Application for a non-material amendment following a grant of planning permission.
Town and Country Planning Act 1990

Application under S73a for Variation or Removal of Condition relating to planning permission 0993/08 Town and Country Planning Act 1990 - To vary approved plans as per drawings received 26th May 2021.

The Old Stores, Stone Street, Crowfield, Suffolk IP6 9SZ

FOLLOWING RECEIPT OF OUR HEATLOSS CONSULTANTS SAP CALCULATIONS WE NEED TO INSTALL AKN OF PHOTOVOLTIC PANELS TO THE ROOF ON THE SOUTH FACING FRONT ELEVATION.

Drawing No. PA
21-2021-02

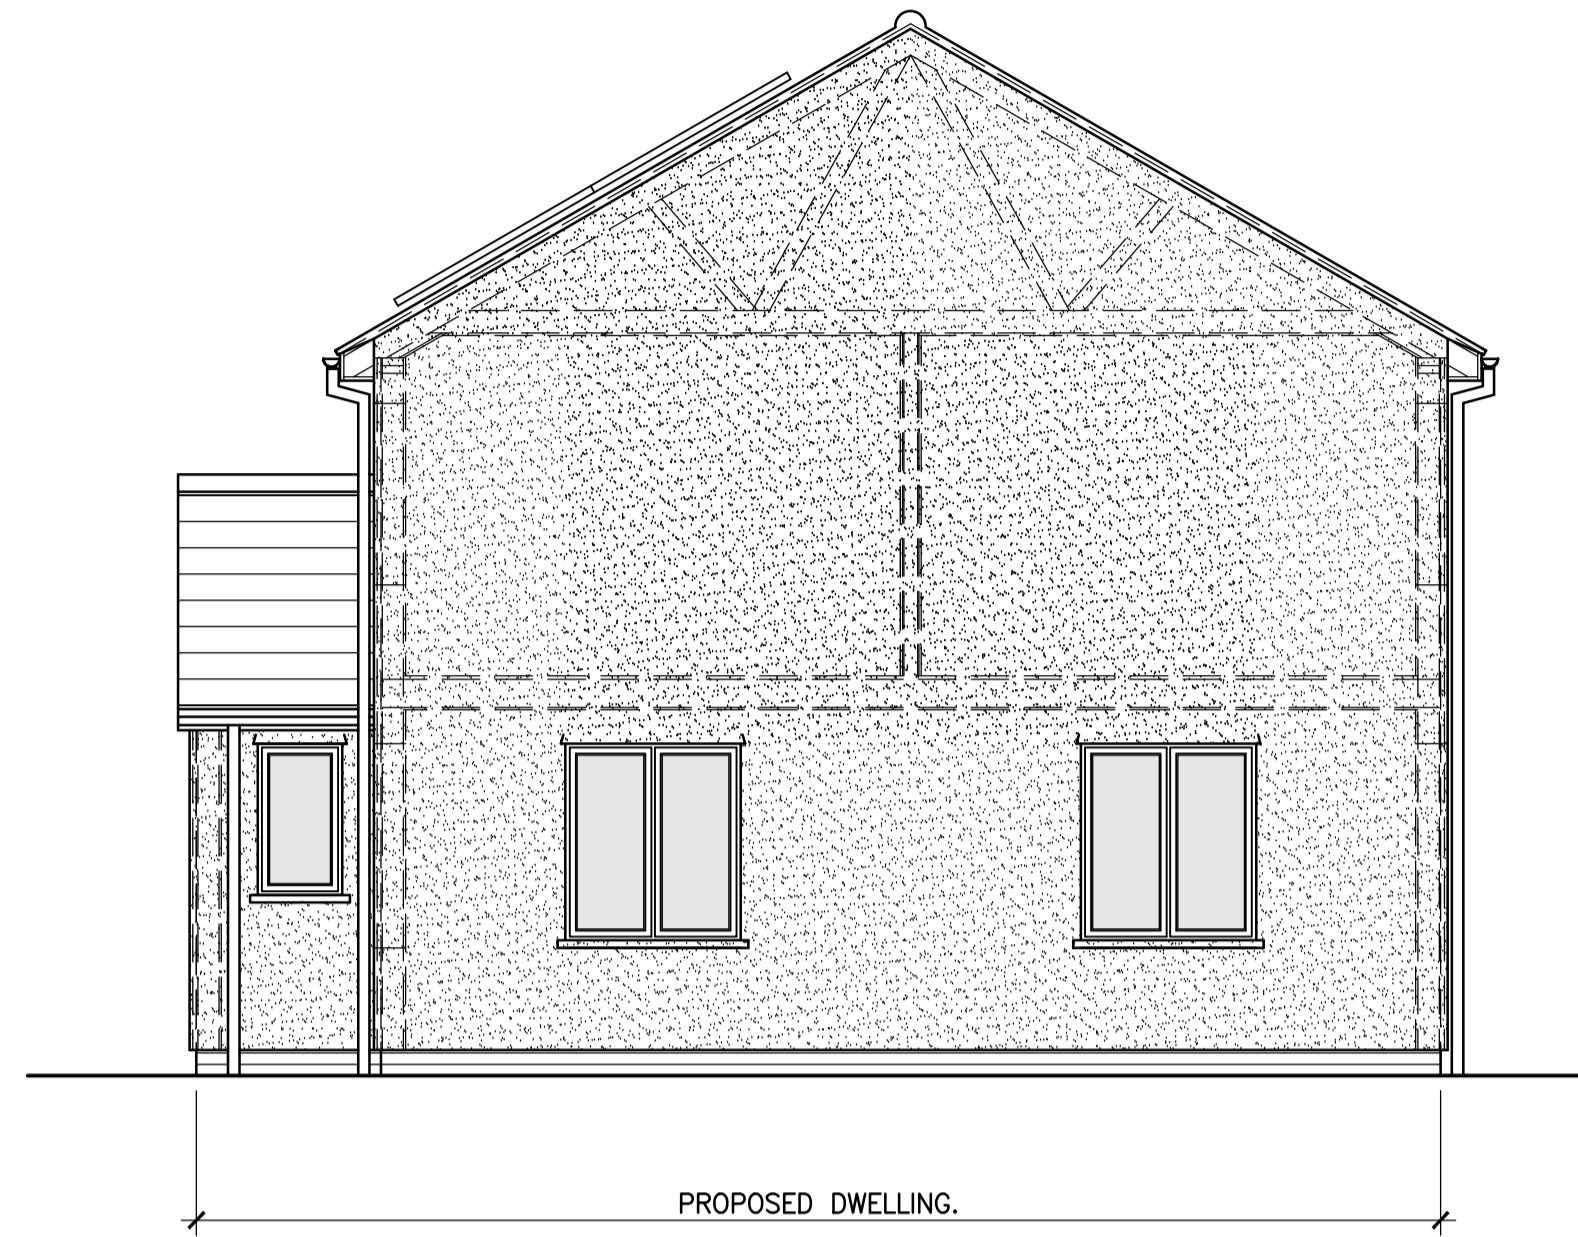
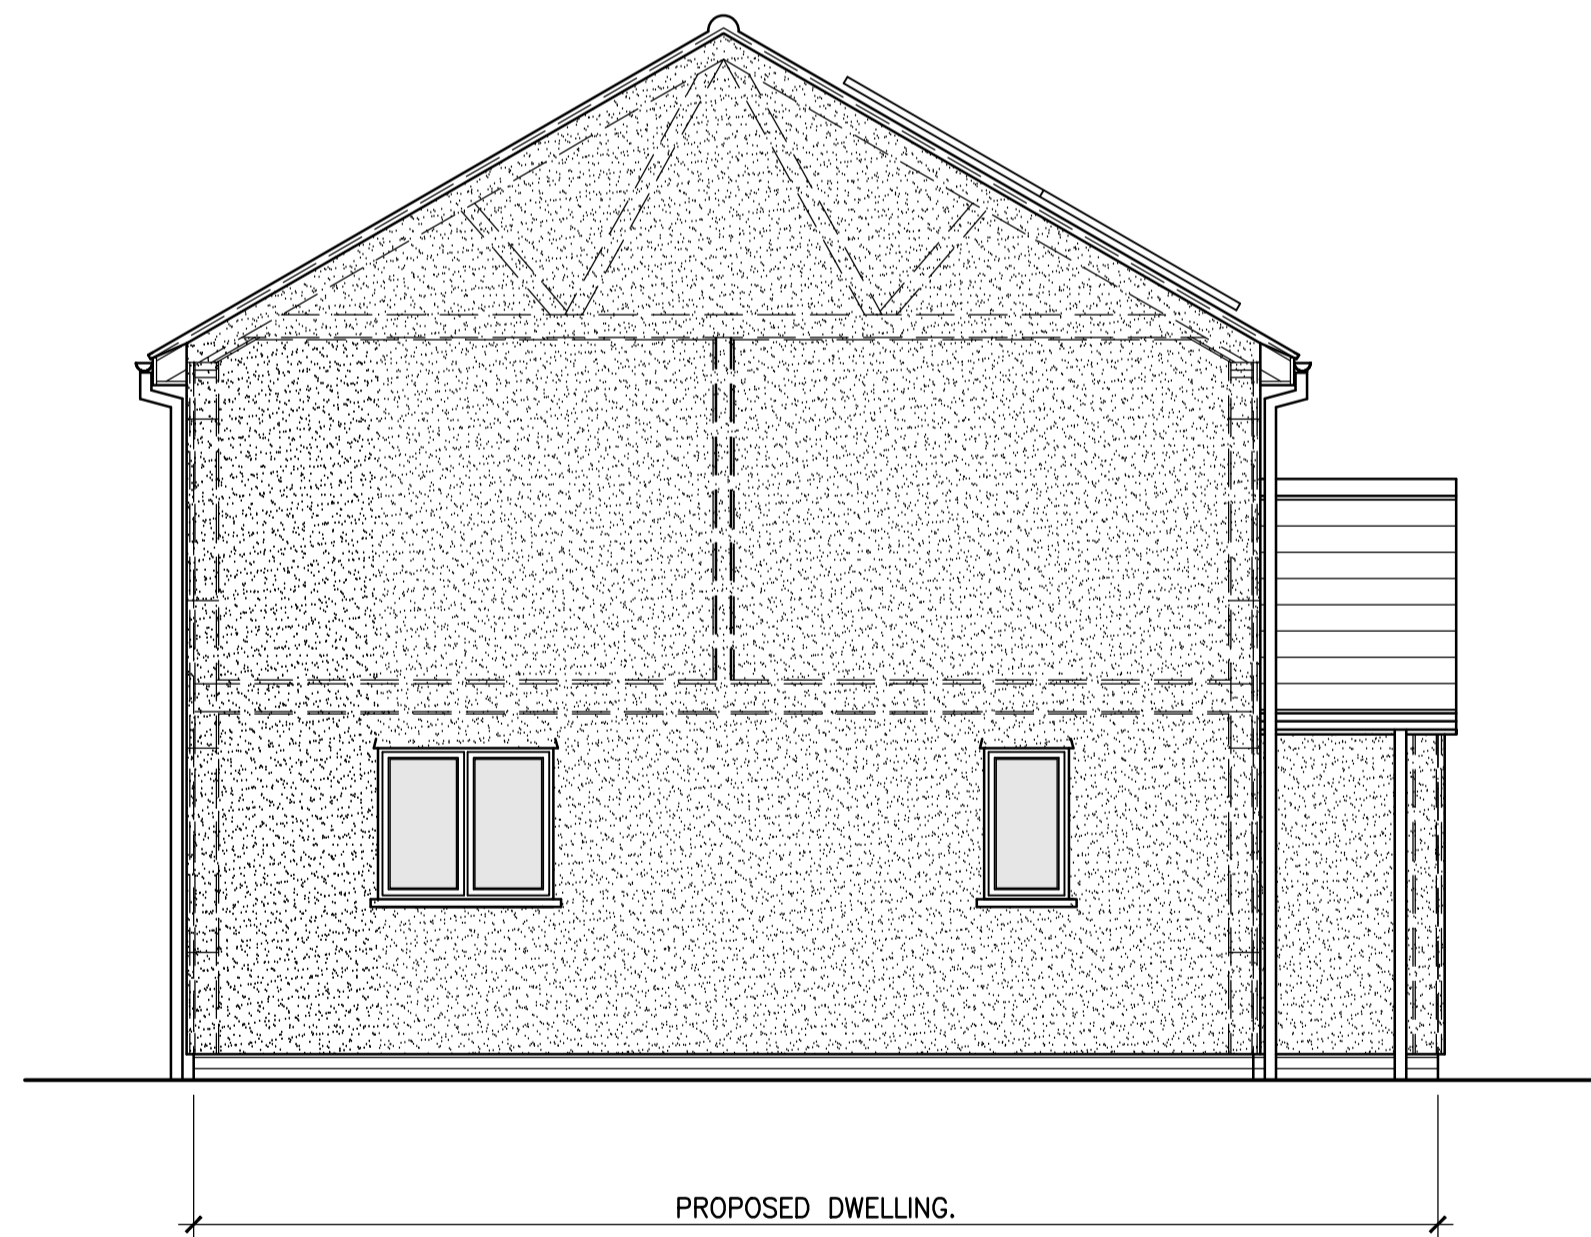
WE ALSO WISH TO RAISE THE CILL HEIGHT ON THE REAR KITCHEN WINDOW TO ENSURE THAT THE WORKTOP FITS UNDERneath IT.
